Appeal Decision

Decision date: 27th February 2018

Appeal Ref: APP/A2525/W/17/3187557

Fourth Haven, 57 Station Road, Long Sutton, Spalding PE12 9BS

Drawing No 16/479/PA/001

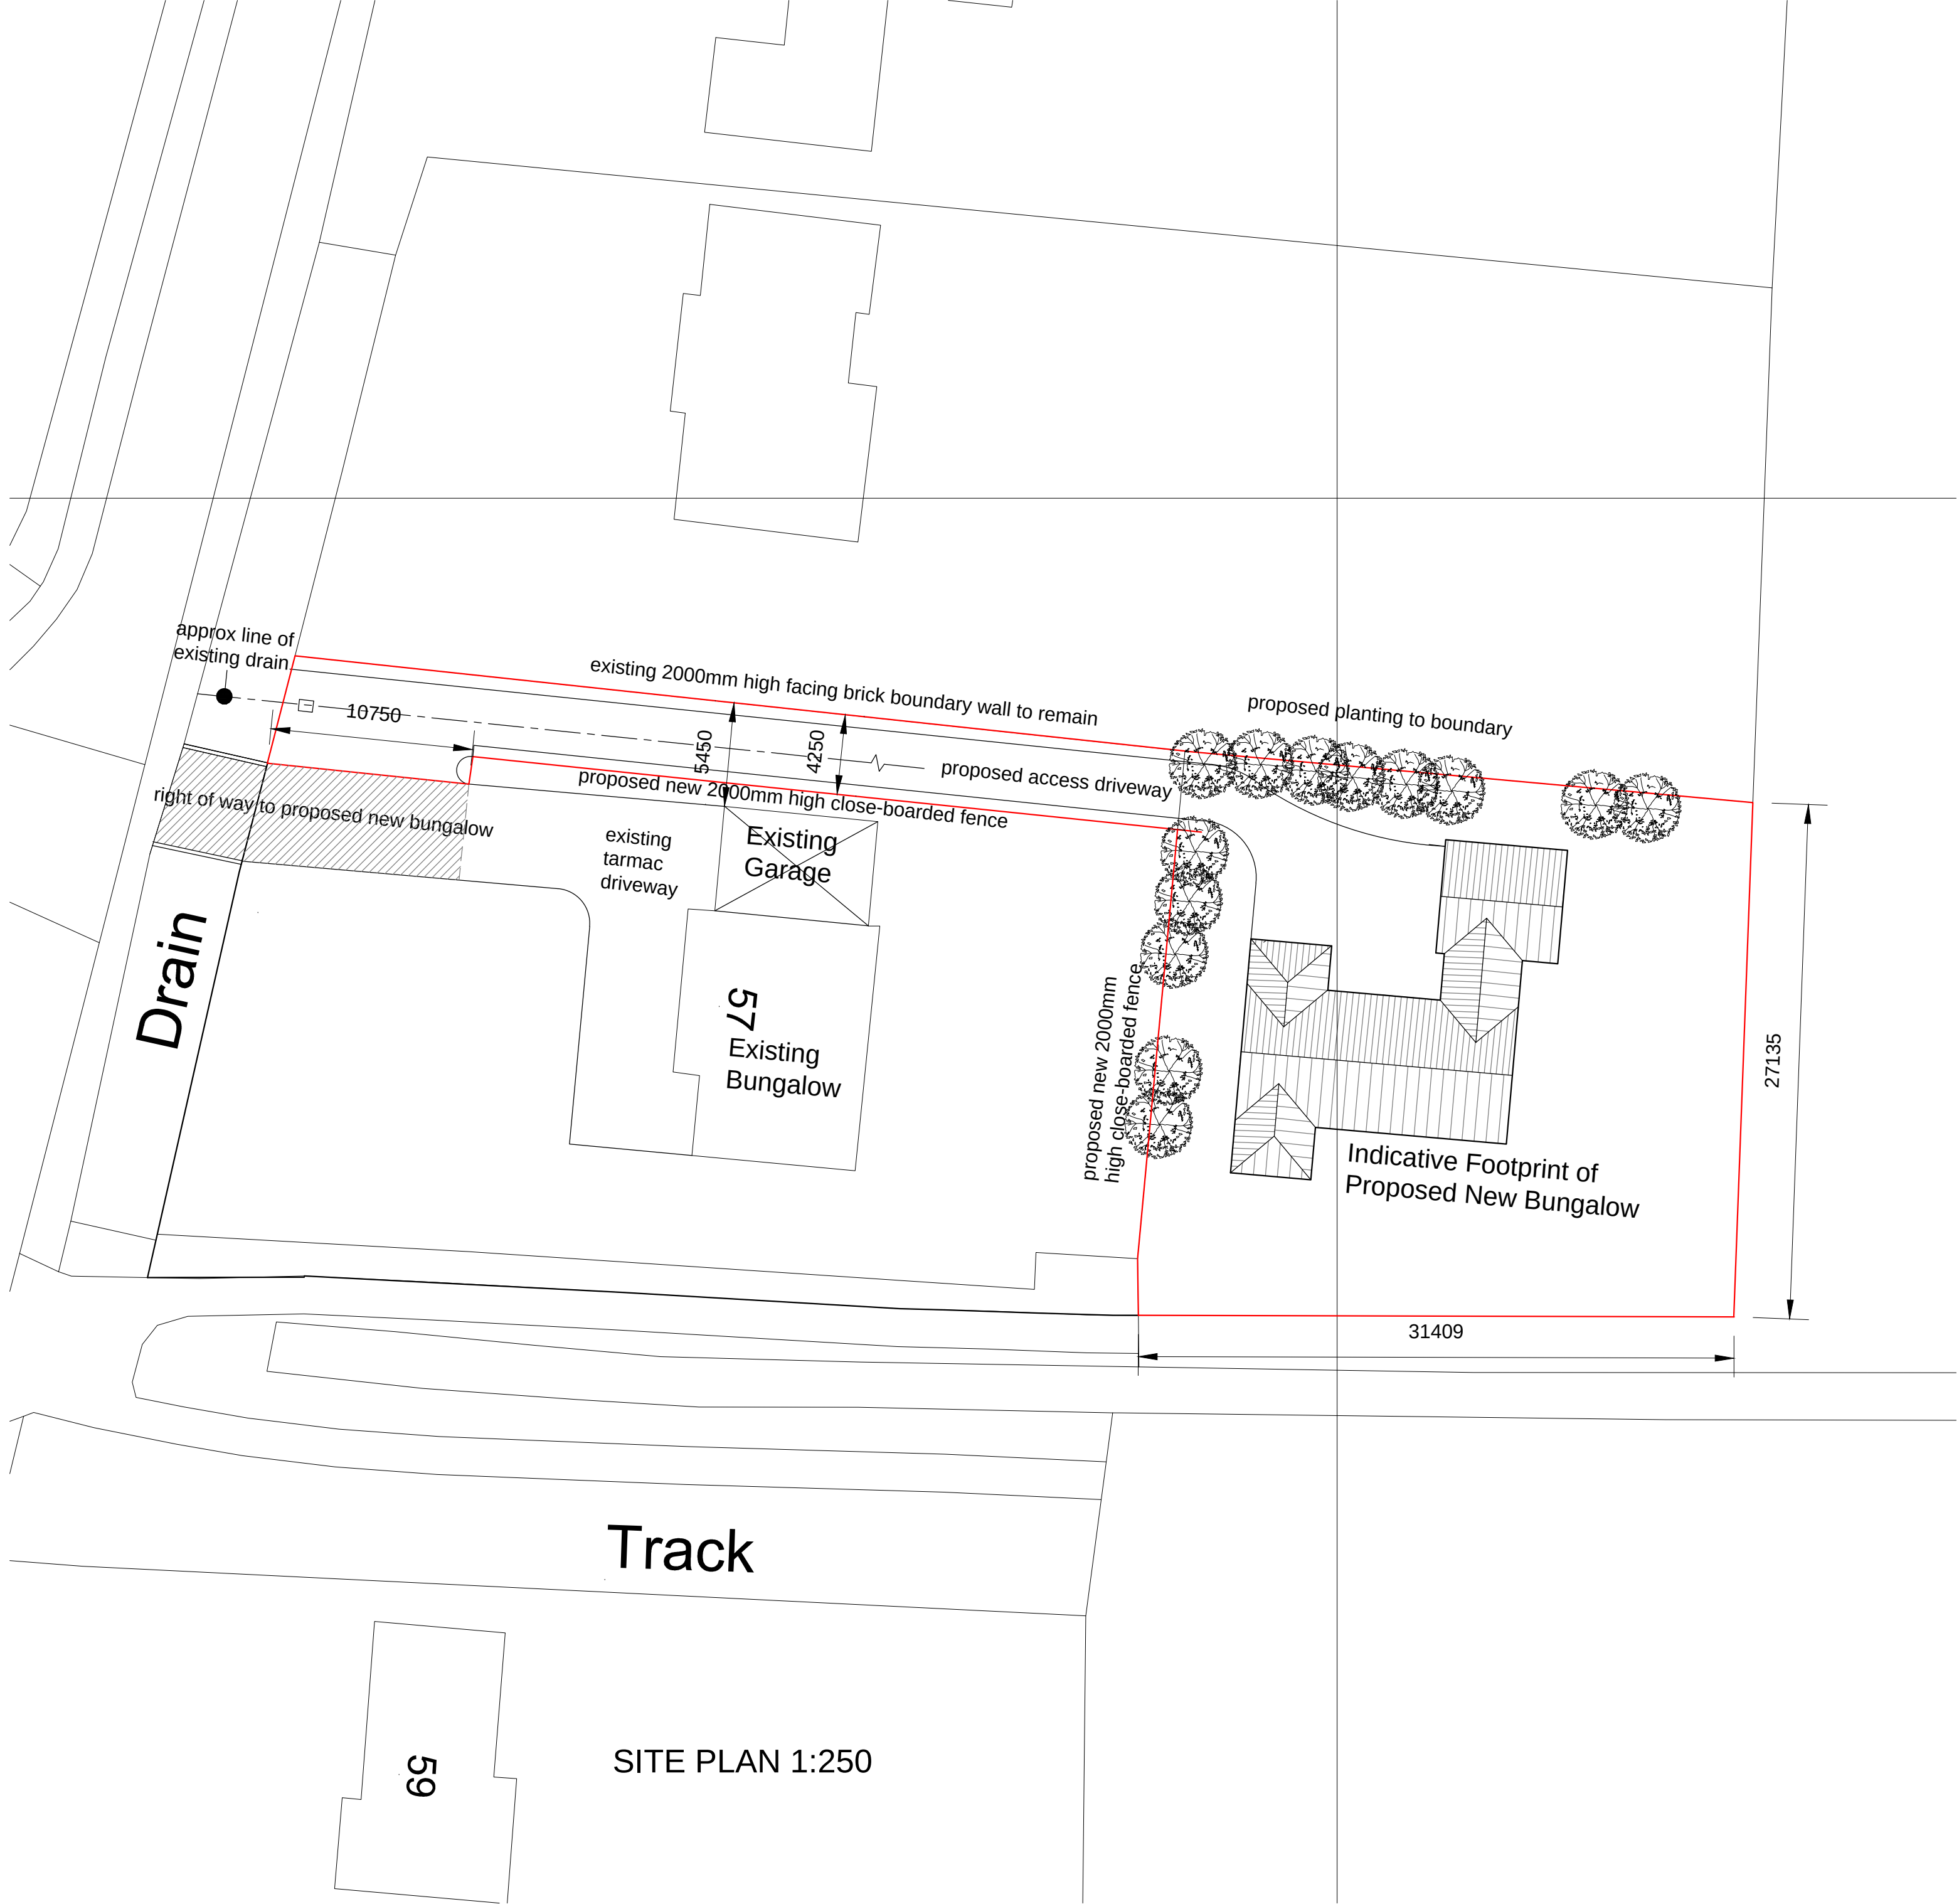
15. In order to prevent loss of privacy and an over-bearing effect for occupants of neighbouring properties, the indicative plan shows the proposed dwelling at an acute angle to the adjoining properties. This would be out of keeping with the dominant prevailing grain of local development along this part of Station Road, where properties generally directly face the street.

16. I acknowledge that the layout plan is indicative only. However, due to the constraints of the size and shape of the site, its relationship with adjoining properties and the necessary flood risk mitigation, there appear to be few, if any, feasible alternative ways of developing a dwelling on the site. Whilst acknowledging the varied edge to the settlement I conclude that the proposed development would result in an incongruous and over dominant visual intrusion that would be harmful to the character and appearance of the area.

17. The proposed dwelling would be accessed via a driveway through the front garden of No 57 adjacent to the boundary with No 55, and without a street frontage as such. Backland development in itself may not always be unacceptable. However, in this instance, for the reasons set out above, the proposed dwelling would have an incongruous and unsatisfactory relationship with the host and neighbouring properties.
